TREE TRANSPLANTERS AUSTRALIA PTY LIMITED

17 November 2016

Re: The Terraces Project - Presbyterian church Paddington

Following the correspondence in regard to the relocation on site of the mature palms at the above project, I offer the following comments in regard to root plate size and potential re-establishment.

**Option 3** | Infill Planting of *Waterhousia floribunda* and Transplanted Palms With Staged Removal of Selected Weed Trees

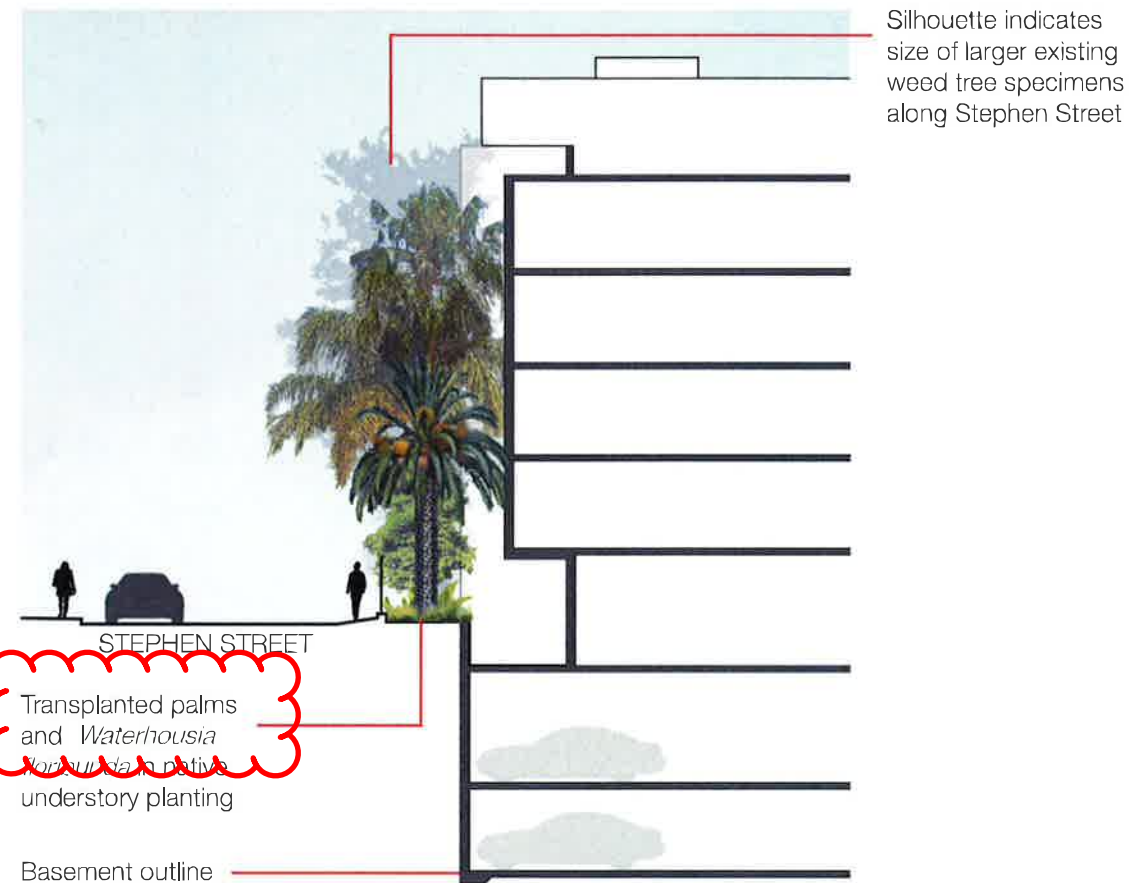
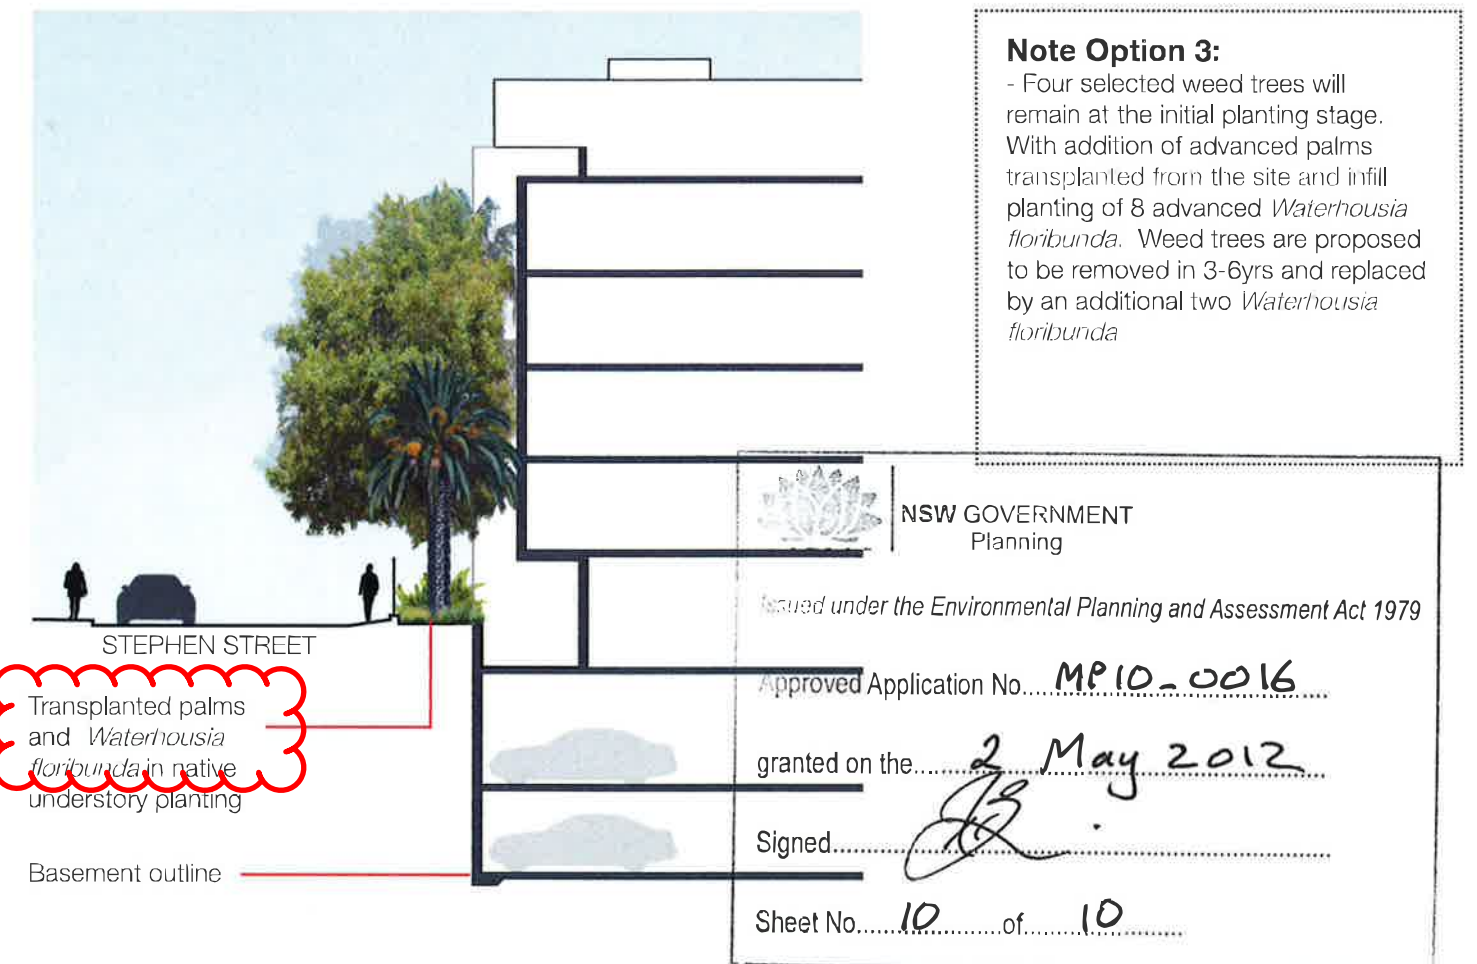
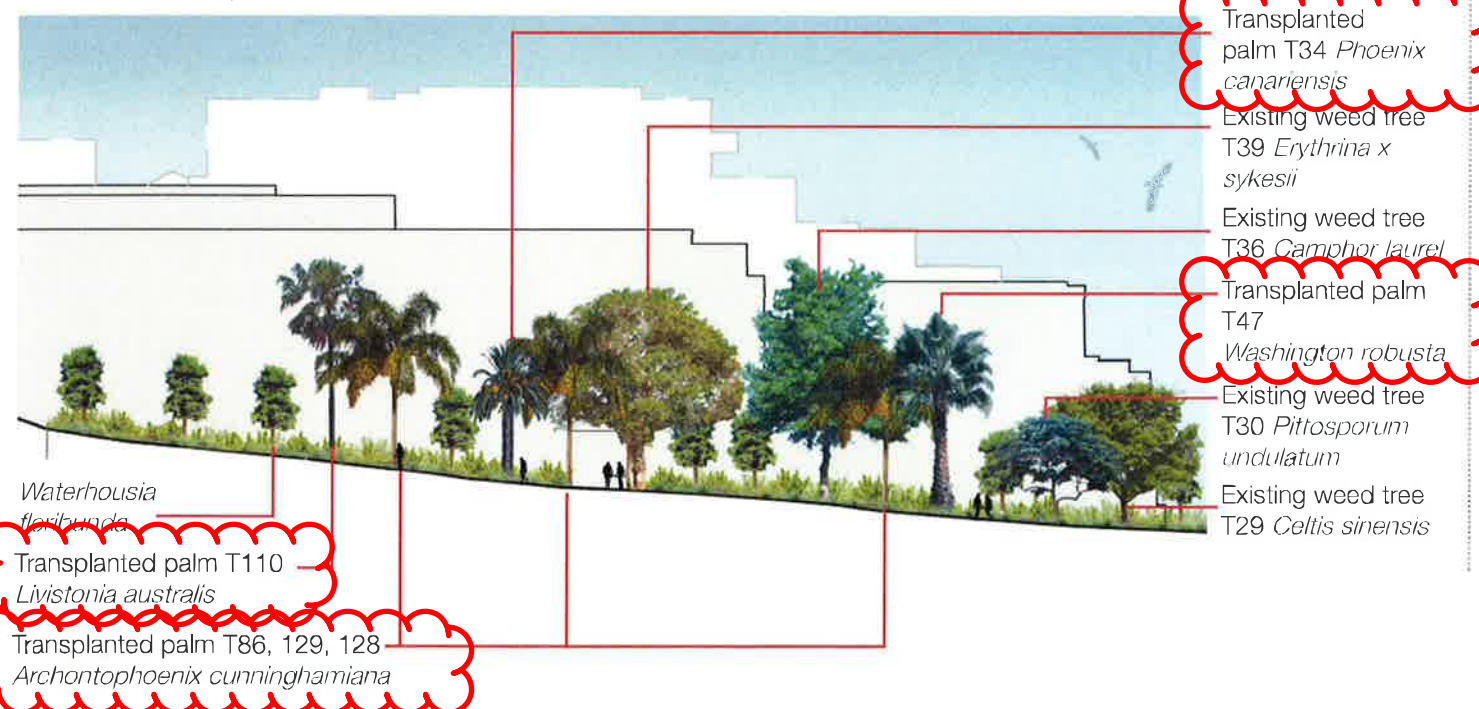
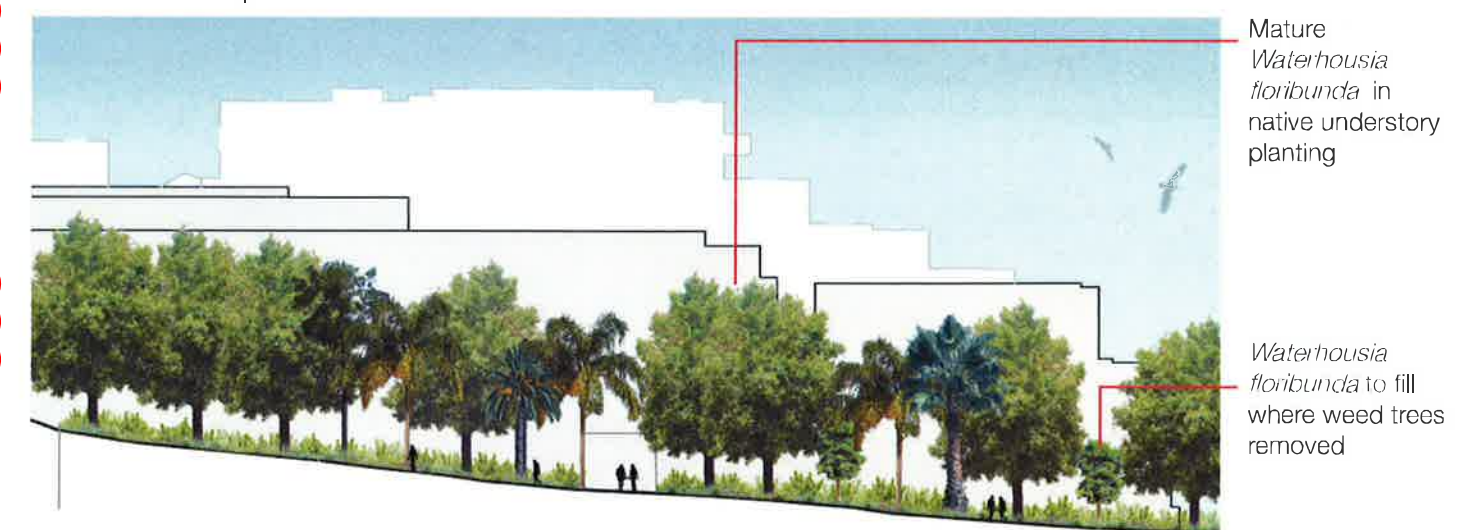
It is my understanding that some of the palm trees nominated for transplanting on site are to be relocated to potential new locations along Stephen Street. Due to the advanced size of the nominated trees to be transplanted, there is concern that there is not enough planting area to accommodate the root plates of the trees. Their root plates would need to be reduced to a size that is smaller than what would be considered appropriate and this will impact upon the trees ability to survive the transplant procedure.

The palms nominated for relocation on site shall have root plates ranging from 1.5 metres to 2.5 metres in width once they are prepared for relocation and therefore their new locations will require planting positions of between 2.0 metres wide (4m²) to 3.25 metres wide (10.5m²) and anything less will compromise the capacity of the tree to be self supporting as well as retaining the vitality to sustain the transplant procedure.
